Subject: LU/84/21/PL & LU/85/21/L

36 - 38 Surrey Street Littlehampton BN17 5BH

Change of use of premises to a mixed use comprising of 1 No. 4-bedroom HMO unit & retention of 1 No. bed-sit unit at first floor; 2 No. holiday let use units at ground floor with reduction in size of retained hairdressers & ancillary retail storage space & staff facilities to be provided at basement

First Floor Plan

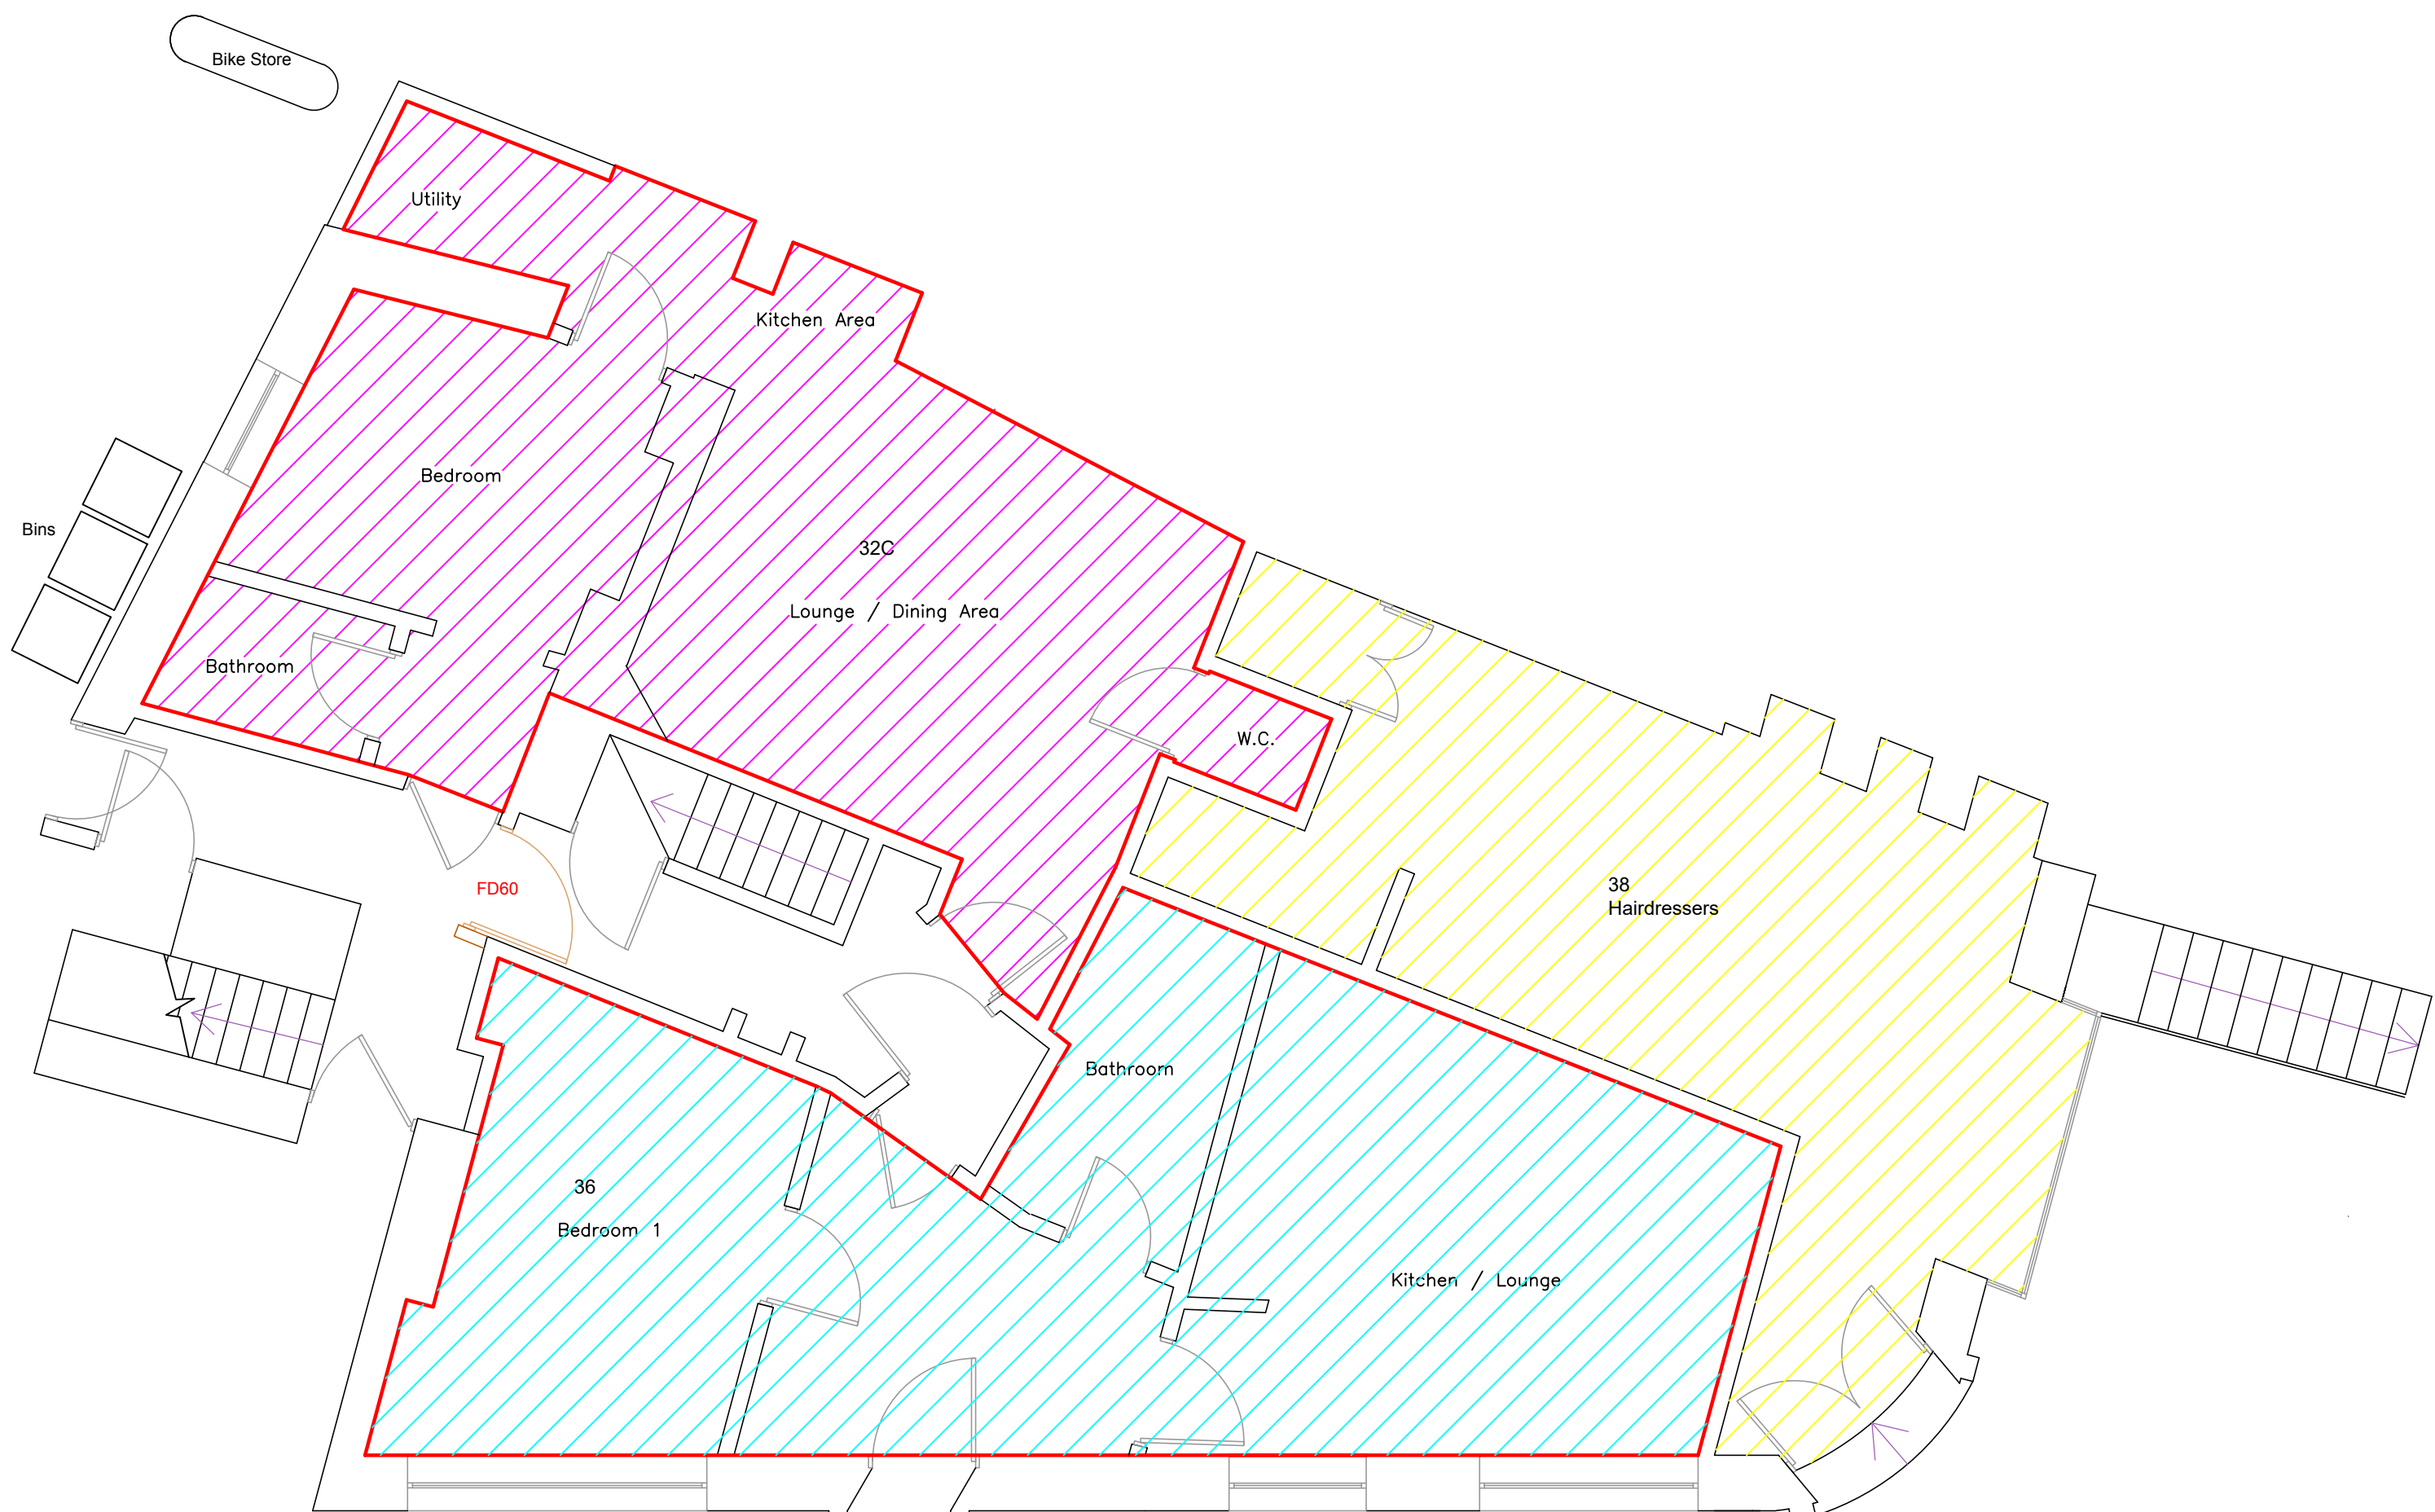
It is evident from looking at the existing and proposed floor plans that a significant amount of internal works have been undertaken in order to accommodate the new uses. As the works are in part retrospective, it is not possible to determine the scale of the impact i.e. in terms of the loss of historic fabric. It is considered that the proposed/implemented floor plan is acceptable as the majority of the floor plan is retained.

It is positive to note that there will be no alterations to the exterior of the building and that the Surrey Street frontage will maintain an active, commercial use.
